Re SSD-3276623035-75Harrington Street, The Rocks

I object to the proposal in its current form.

Figure 43 Bridge Stairs- view with proposed envelope (yellow outline) and detailed design

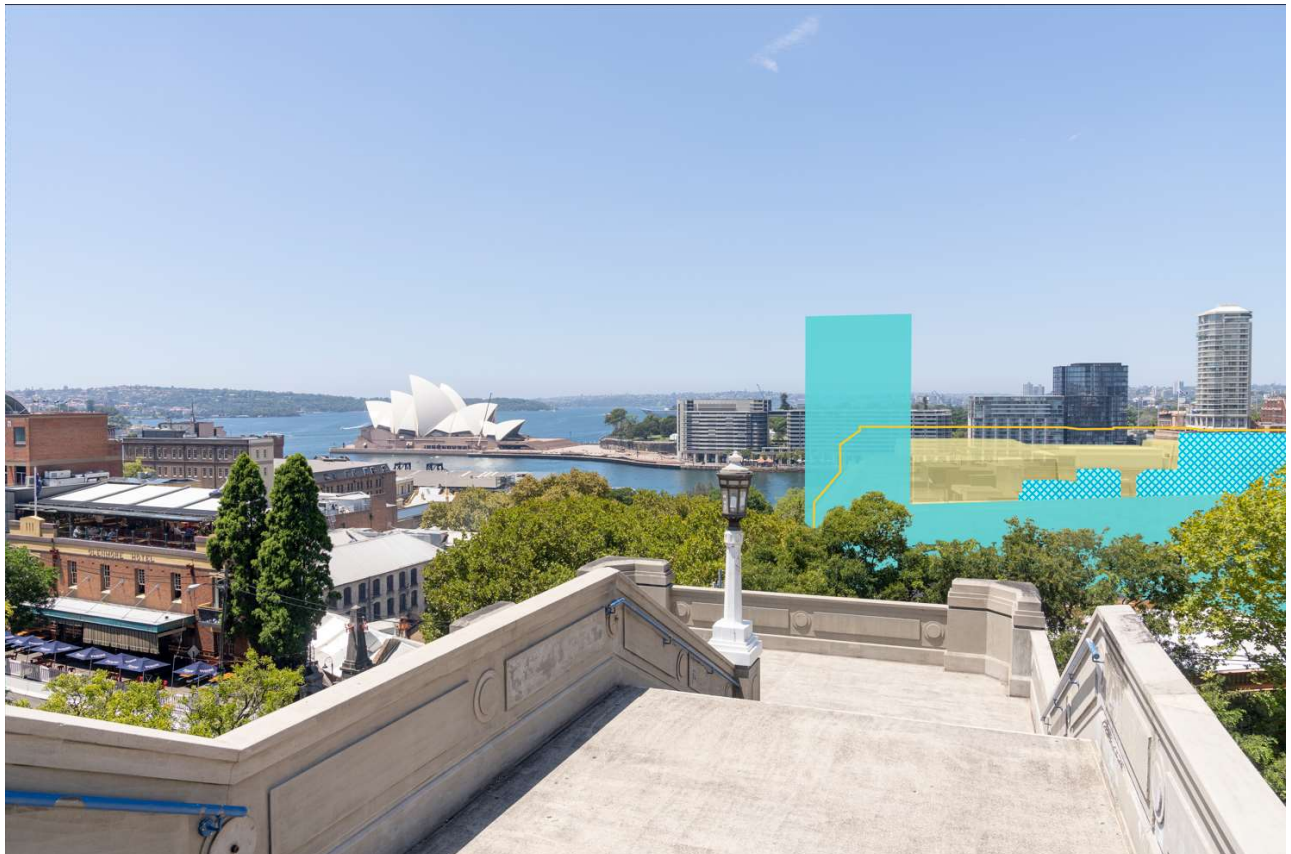
- While the vista to the Opera House is not impacted by the proposed plans for the 8 + storey building (~ 42 metres), the plans will block the view to East Circular Quay and the harbour in part. In doing so, the plans compromise the largely uninterrupted view that extends from the Sydney Opera House to East Circular Quay.
  - Notably too, the current view is not a flat surface as indicated in the VIA (page 77) that concludes '*the degree of any view loss is minimal*'. Rather the loss of the view when considered in its context is significant. Notably too, this view is different to that from other locations such as from the Cahill Expressway.
- b. The current view from the top of the Cahill Steps (differs in part to that shown in the VIA)

- c. In comparison, what's proposed (massing/proposed envelope courtesy of the VIA, pp 77)  
See over.

- d. The London Planes (described in the VIA as '*established vegetation*') shown in the images are about four to five stories tall. Yet it appears no consideration was made in relation to the future of the 'vegetation' aka trees and the visual impact if any changes are made. For Example: it should not be assumed the plane trees will survive over the medium to longer term given their age and the impact from climate change. Instead over time, the trees may need to be replaced, or other species introduced as indicated in the draft City of Sydney Street Tree Masterplan and draft Urban Forest Strategy that has recently been exhibited. While the area is under the management of Place Management NSW for the Crown, the City's (draft) urban tree strategy or the like may be relevant when considering view lines and vistas.

- e. The Variation Request indicates the height increase is to afford the inclusion of the additional top storey, i.e. the bar, pool, entertainment area, with the report noting that the application is designed to '*enhance views of the harbour for visitors to the hotel*'.

At the same time, the longstanding public views from the Cahill Steps will be impeded. This seems contrary to the greater public interest.
